14 February, 2011

Application No.: Major Project Application MP 10_0105
Property: Lot 201 in DP 1101828,
Site 2A and 3A,
40 Walker Street, Rhodes NSW

Proposal: Proposed mixed residential and retail development.
Re: Urban Design Review for DA for 40 Walker Street

**6 DETAIL PLAN**  
BLDG D - Apartment Type 6  
2 BED - 79sqm Storage - 7cbm (Includes Media Room)

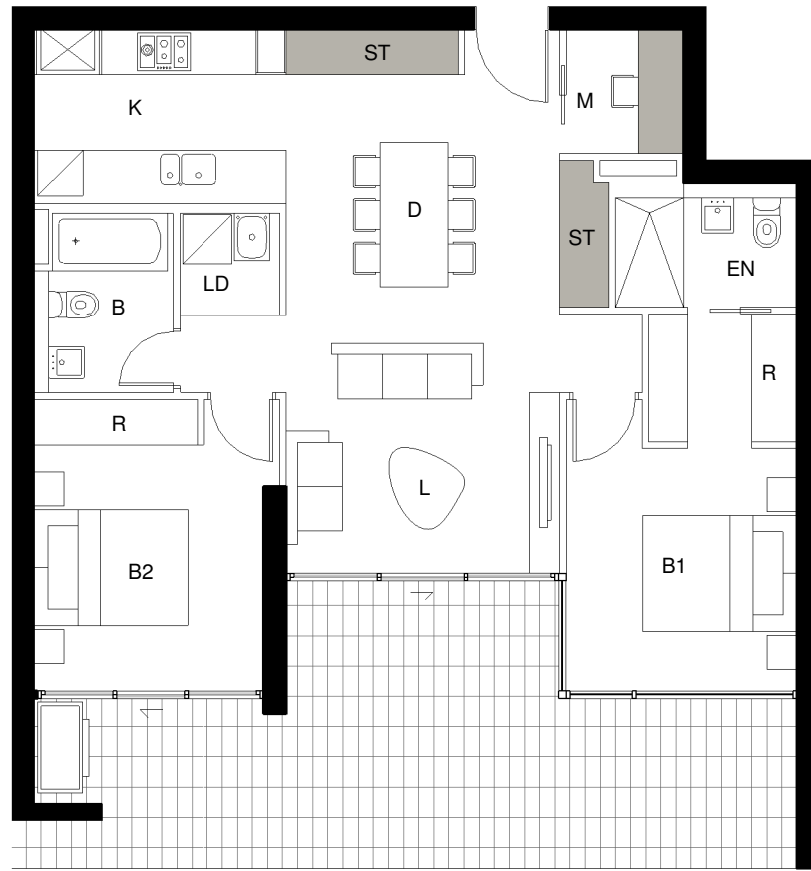
- apartment type 6 – obstructed sunlight access
- apartment type 7-A – distance to back of kitchen is 8.7m
- apartment type 12-A – distance to back of kitchen is 9.2m

1 ELEVATION
Walker Street Elevation
1:350

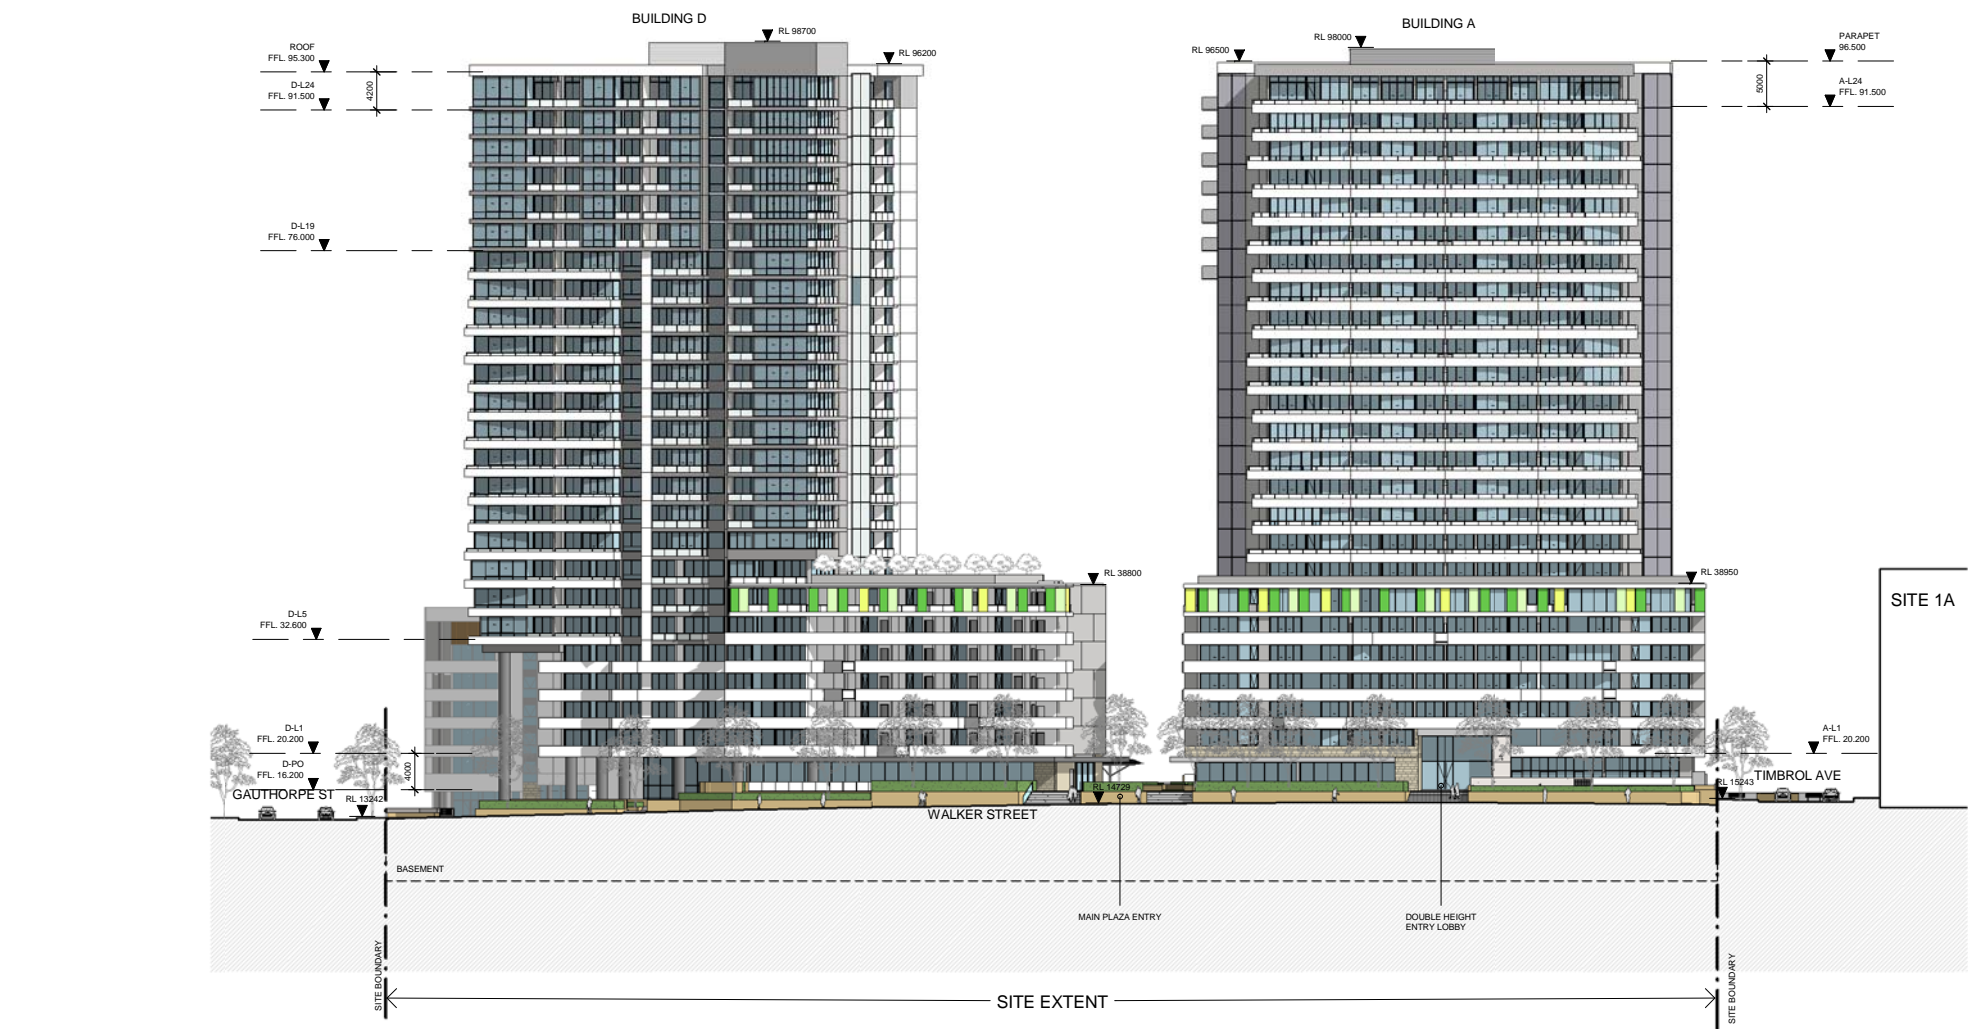
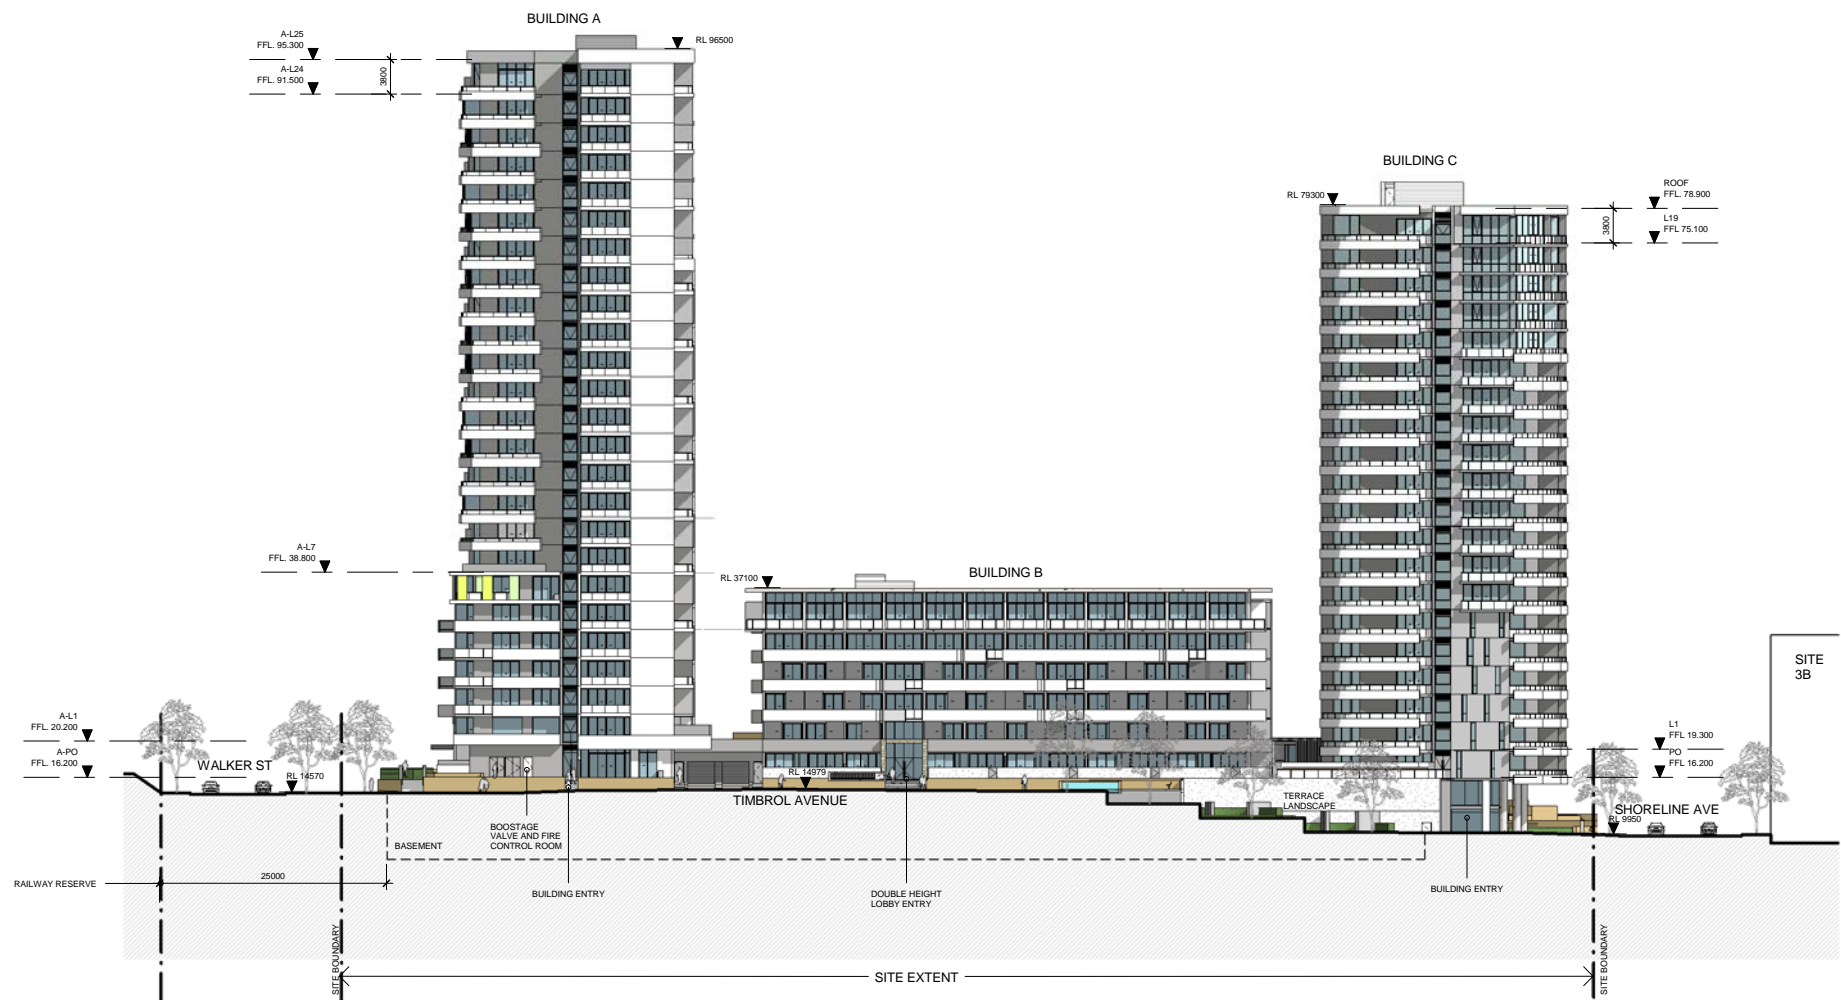
The main non-compliance to the required street setback is to the east along Walker Street. This is a result of a wrong interpretation of the DCP. The DCP diagrams (Figure 81 on page 125 and fig. 82 on page 124) show a podium level built to line within 5m from the boundary. Tower structures above the podium toward the northern end of the block should be set back 10m from the boundary. The proposal applied an overall greater setback to the podium (approximately 7-8m) with a tower structure immediately above, only slightly setback above level 7. It is possible to recognize the podium from the tower mainly because of a difference in treatment and colour to the facade above the 7th level, but not because of the mandatory setback, as required by the DCP.

From an urban design point of view this is a major non-compliance since the street wall setback (podium) to Walker Street should not exceed the requirement. The main role of the proposed 5m setback is to maintain the urban street character along the street wall, define the street edge and give emphasis to the corners of the site. The 5m setback above the podium is also necessary to mitigate the adverse impacts of wind downdrafts.
